**Consultation Response from KC,
Policy****2023/90491 Teas Me, 6, Albert Street, Lockwood, Huddersfield, HD1 3PR****Erection of extension to existing building for outdoor dining/smoking use****Date Responded: 06/06/2023****Responding Officer: HR****Responding Ref:**

Drawing No: HAD3462-03
Scale: 1:100

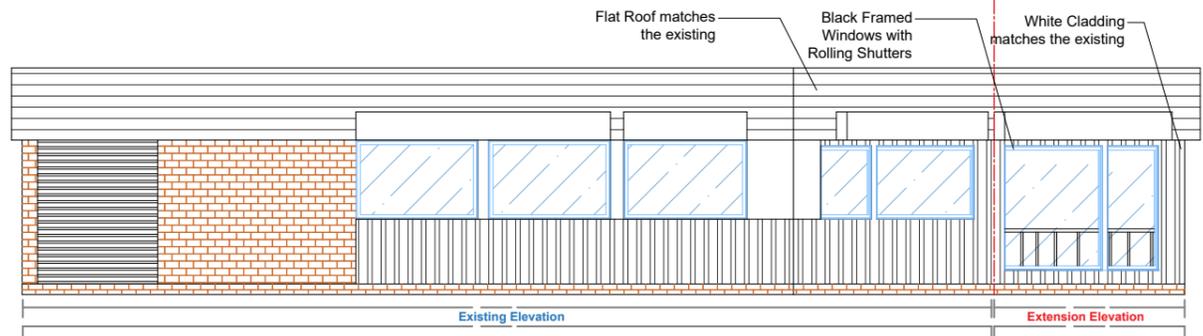
The floor plans (drawing No:HAD3462-03) indicates that the proposed extension is greater than the existing premises and will include a servery counter and a bar as such it is not ancillary to the overall operation. Therefore, the applicant needs to justify the scale of the extension proposed and why the proposal can only be facilitated in that location to accord with policy LP13.
